Subject: **Modification Request for Section 404 Nationwide Permit 23, Section 10 Permit, CAMA Major Development Permit, and Section 401 Water Quality Certification** for proposed widening of the US 17-74-76/NC 133 from the NC 133/SR 1472 Interchange to the US 421/NC 133 Interchange, Brunswick County. Federal Aid Project No. NHS-0017(68); TIP No. R-3601.

References: R-3601 Nationwide Permit 23 and 12, issued July 14, 2014 (SAW-2007-03461-010)
R-3601 Major CAMA permit, issued July 22, 2014 (#89-13)
R-3601 401 Water Quality Certification, issued July 14, 2014 (DWR# 13-0472v.4)

The purpose of this letter is to request modification/re-issuance of the issued permits on this project to account for a change in clearance under bridges 107 and 108 crossing Alligator Creek. Please find enclosed revised permit drawings and wetland impact summary table for the above referenced project. Please replace permit drawings from the original submittal with pages 28, 29, and 44 included with this modification request.

PERMIT DRAWING
SHEET 28 OF 44

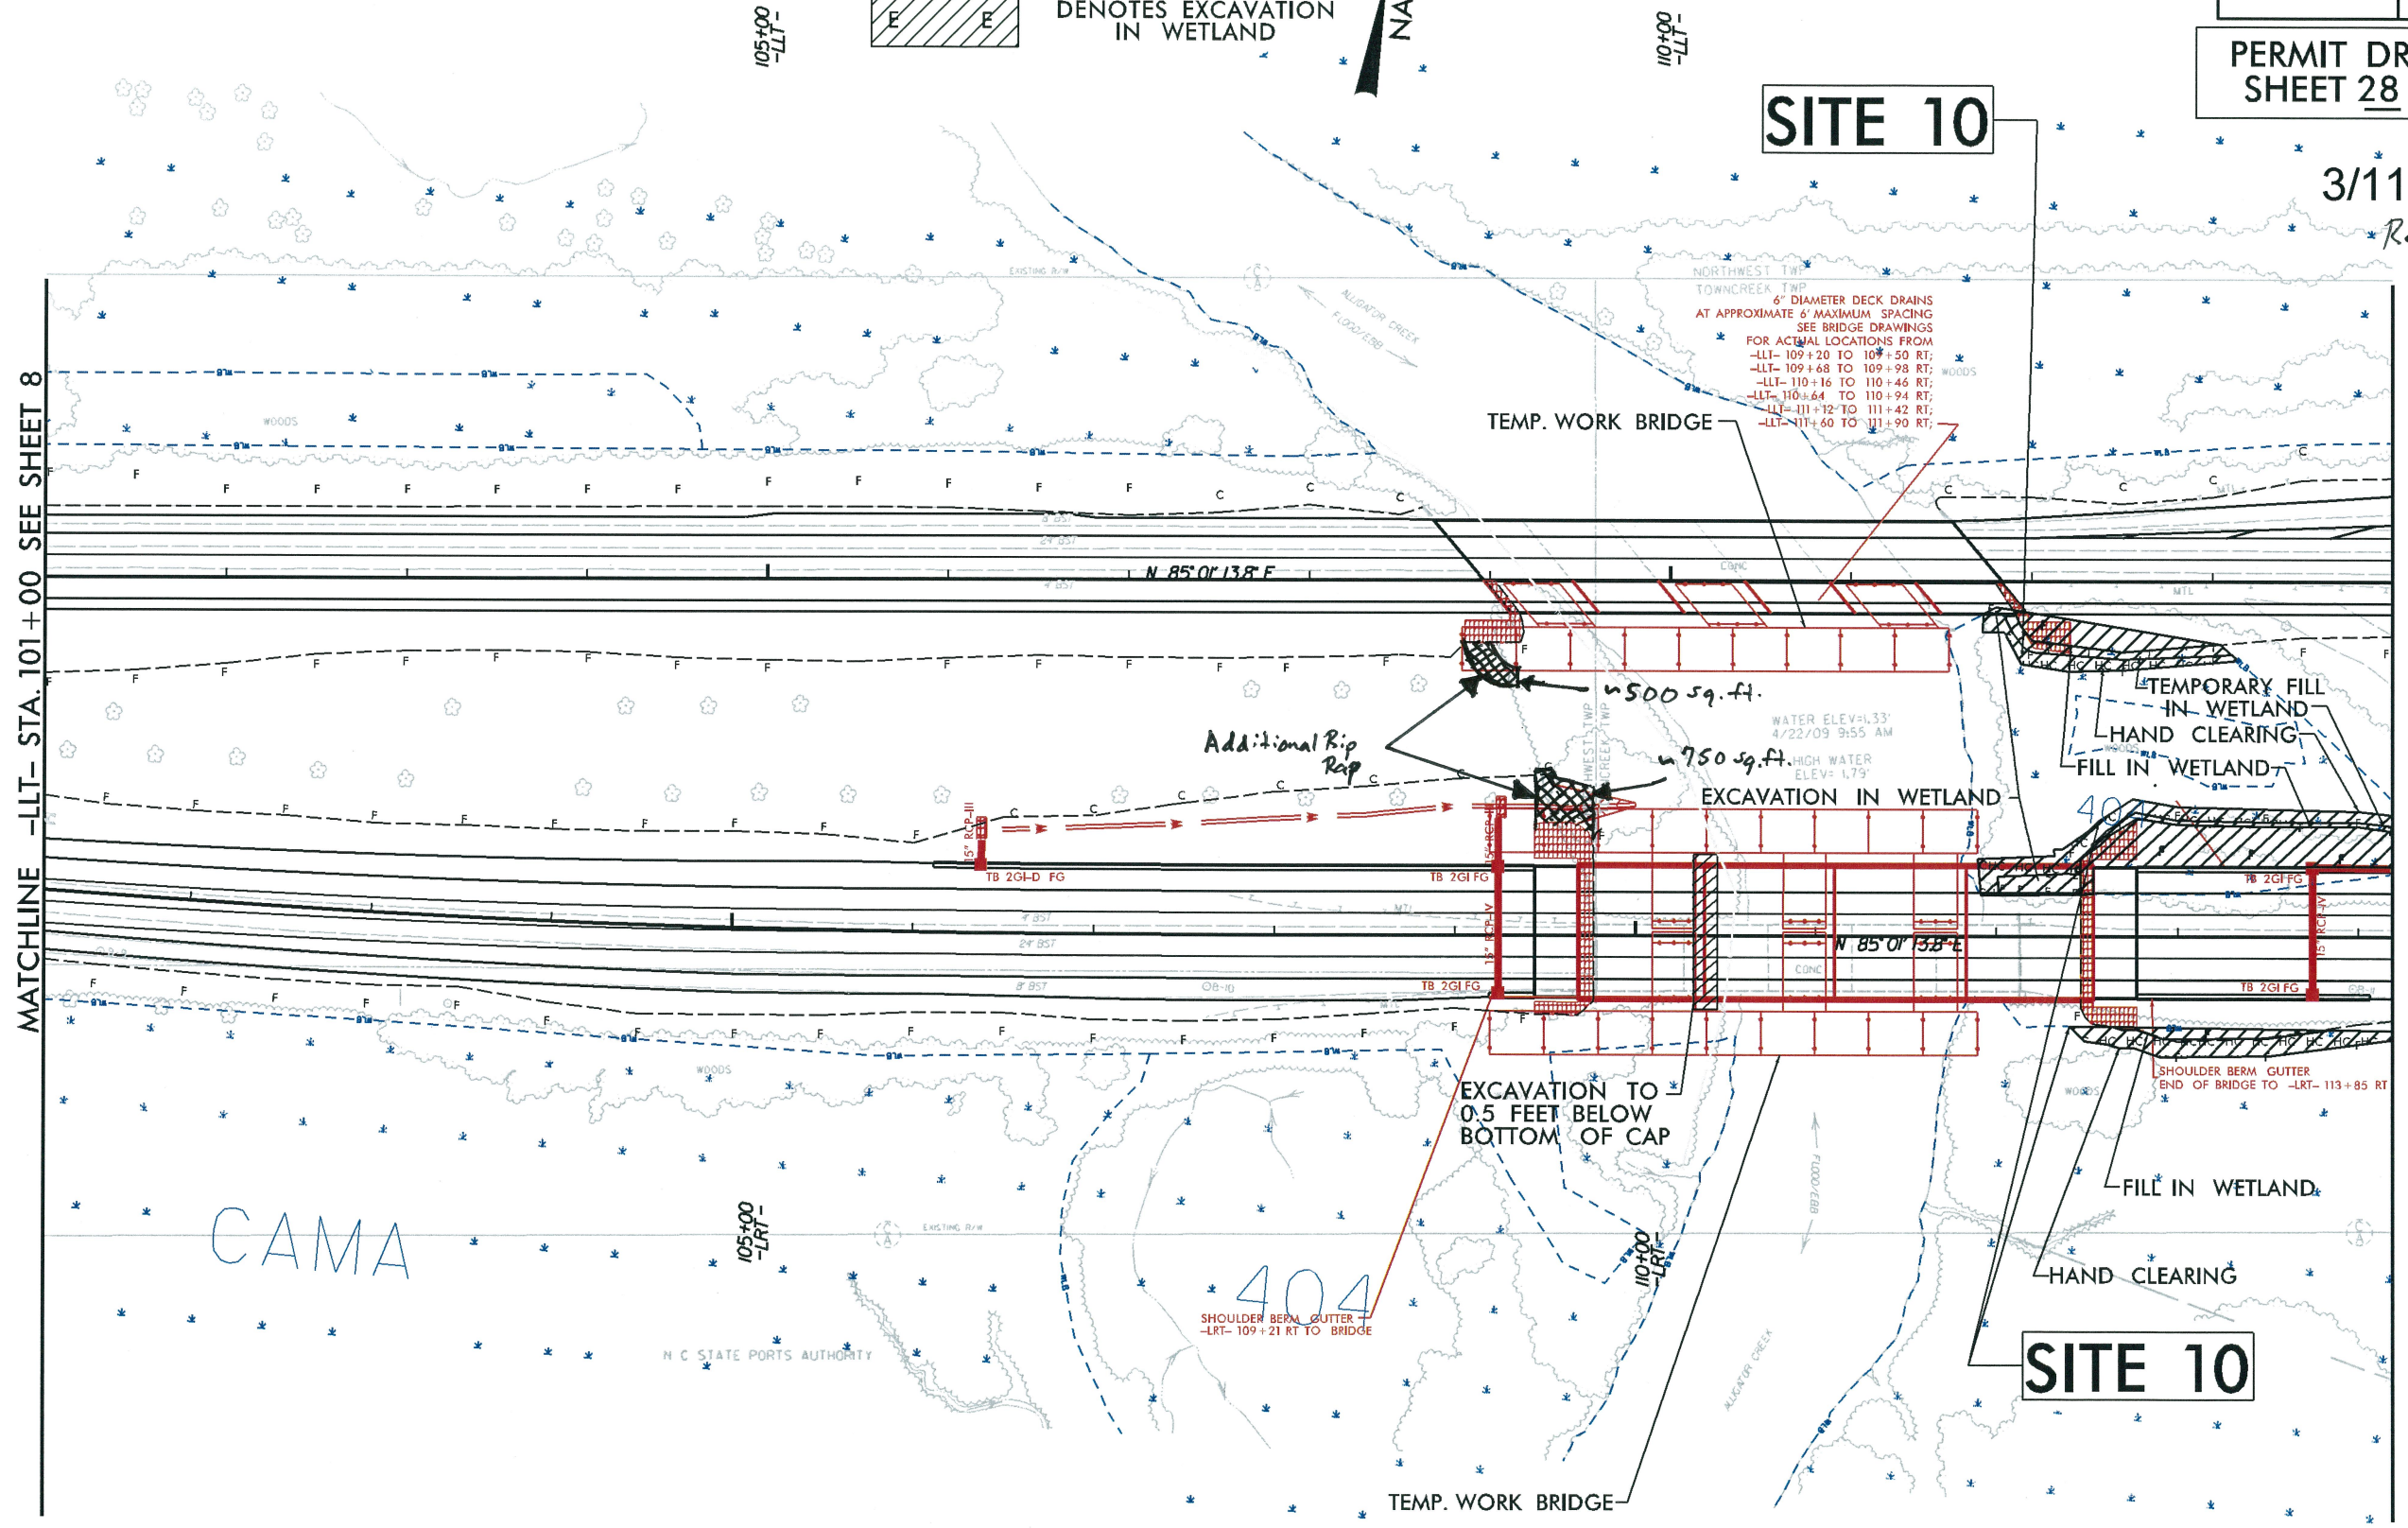
In order to allow for bridge inspection and maintenance, excavation is necessary on the eastern side of the two bridges over Alligator Creek. The previous design called for four feet of clearance however, impacts were not quantified on the previously submitted impact drawings or in the impact summary. In order to minimize impacts, the clearance has been

decreased from four feet to two feet. The newly calculated impacts are included in this modification request. The reduction in excavation limits impacts to streambanks and wetlands, avoids the need for riprap below the tide line, and will not lead to scour of the streambanks. The design change will result in an additional 0.01 acre excavation in wetlands and 0.01 acre of hand clearing from what was previously permitted.

**PERMIT DRAWING**  
**SHEET 29 OF 44**

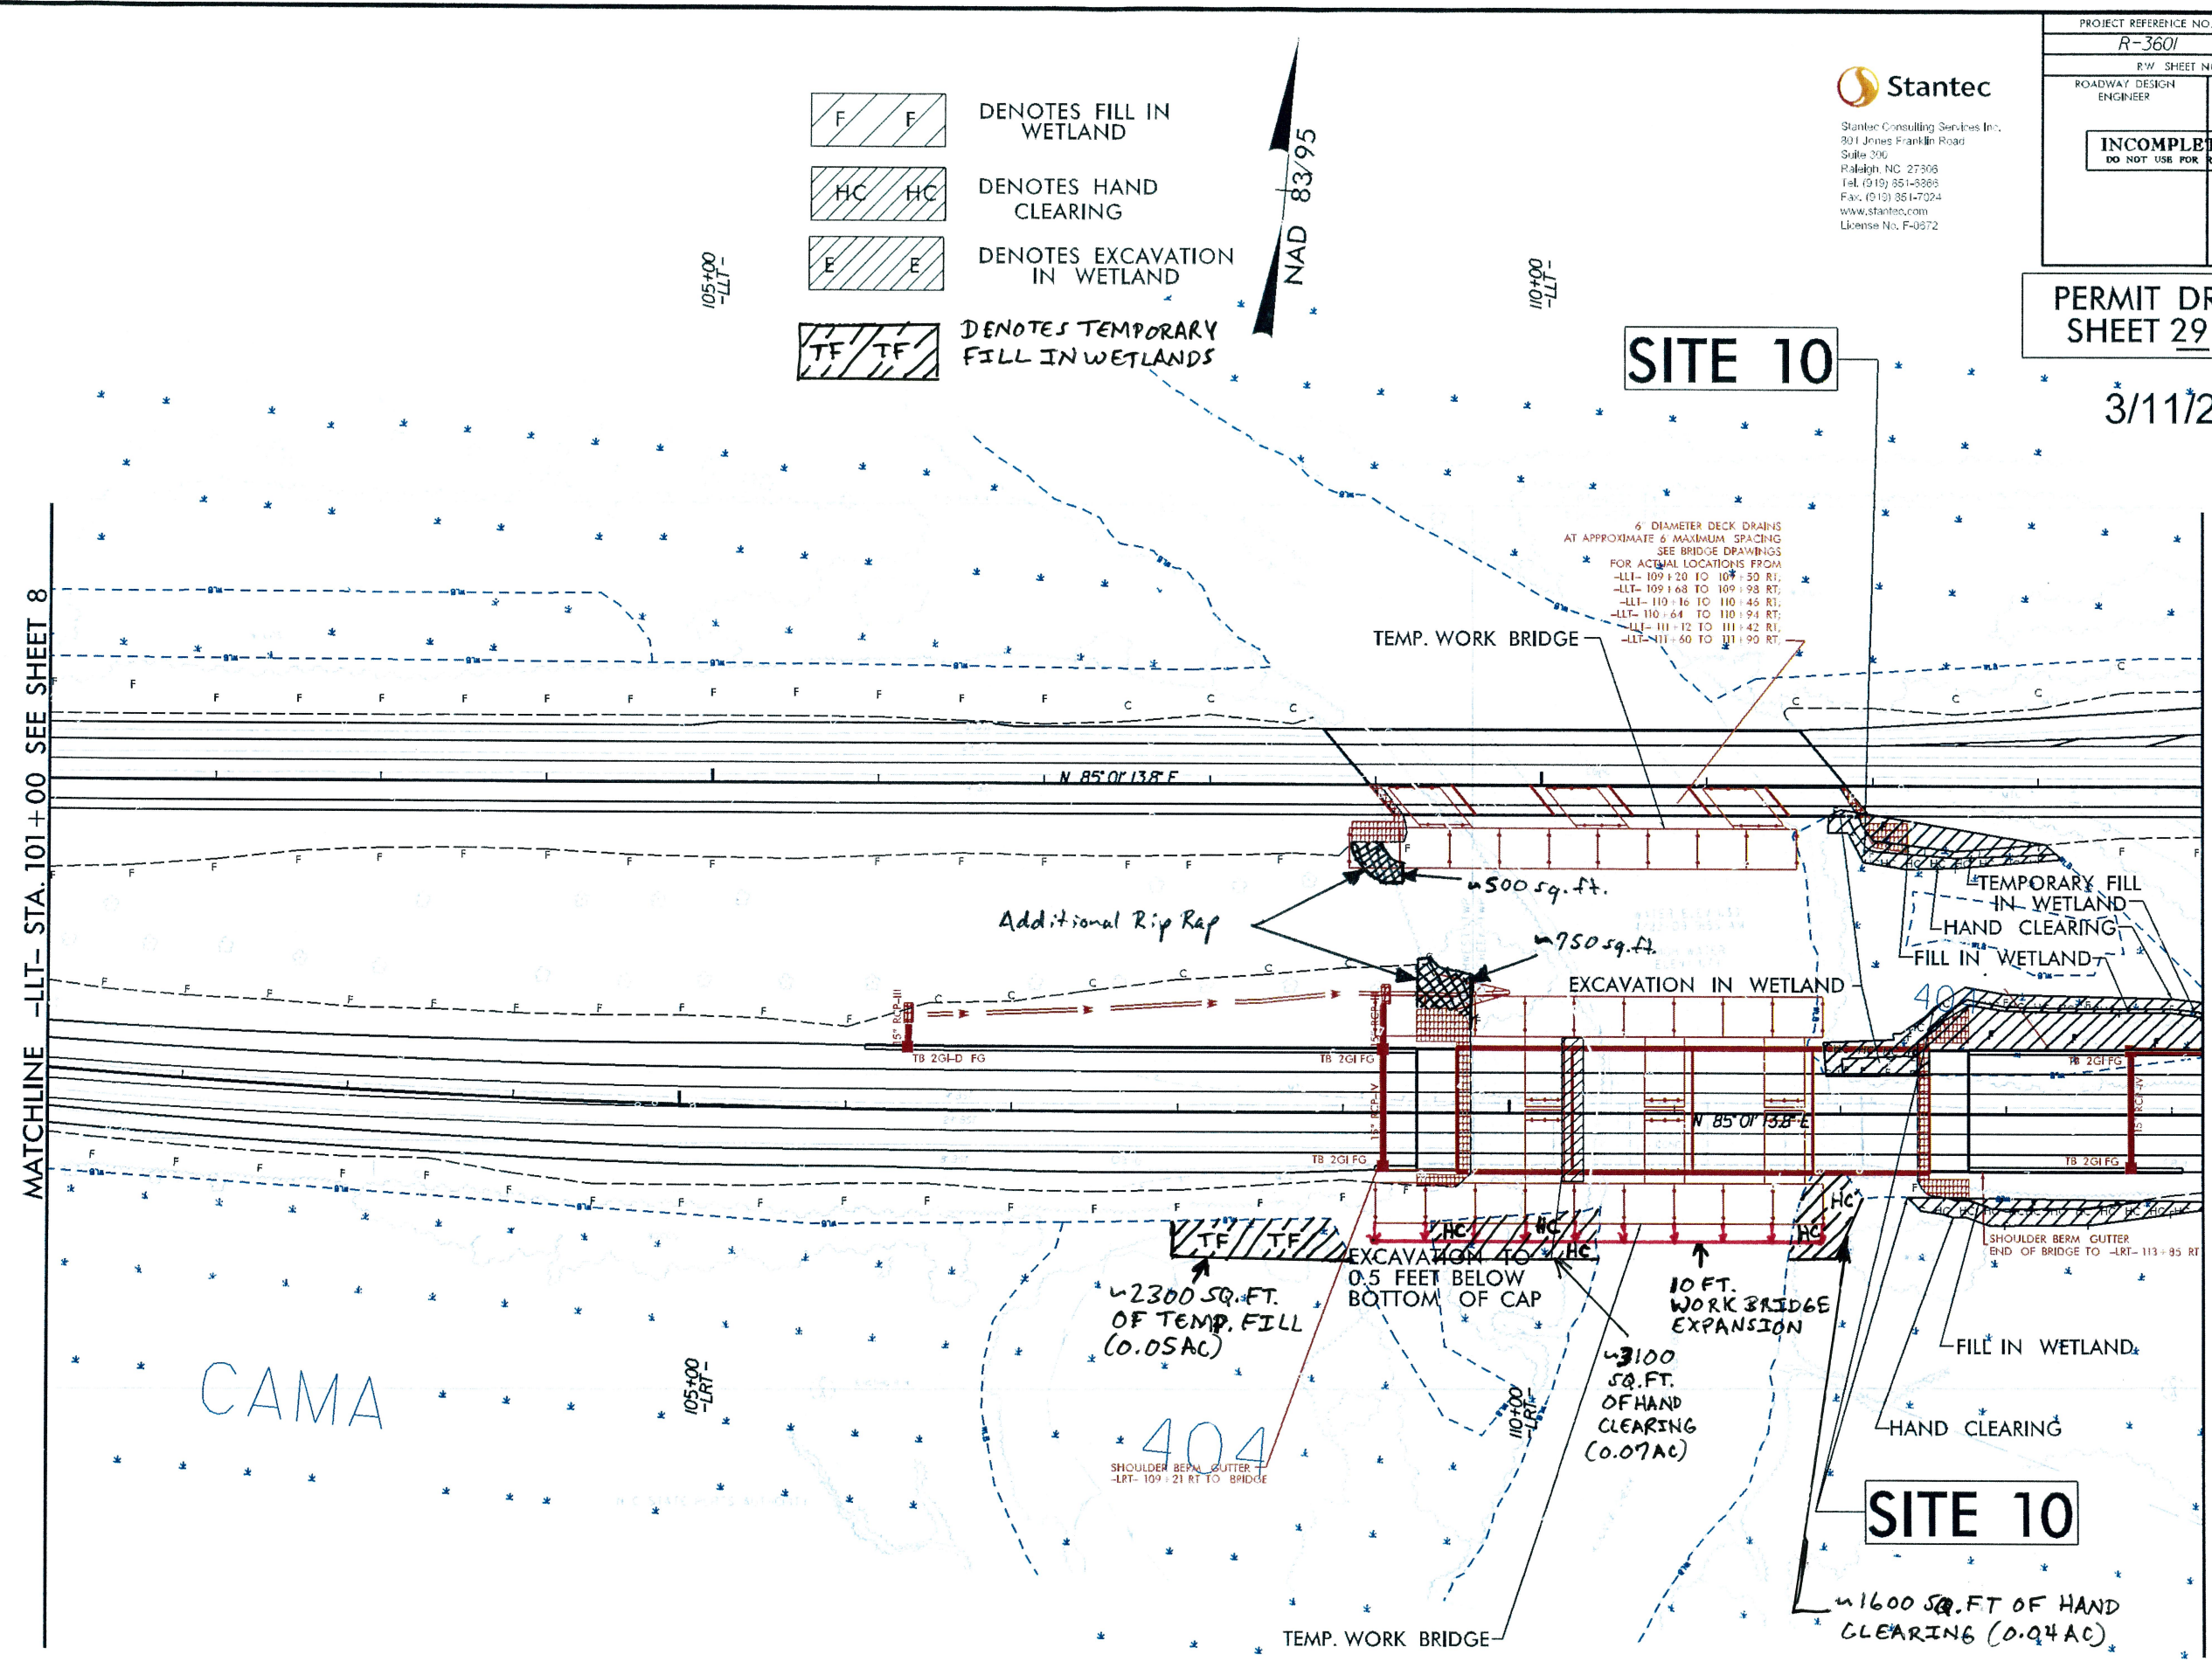
In addition, temporary excavation around end bent one on the northbound bridge has been added to the impact summary (0.03 acres; see note 2). The area to be excavated is not located in a jurisdictional wetland and the elevation in this area is just at or below the tide line as measured for the permit. Due to an increase in tide levels, this area is now below the tide line.
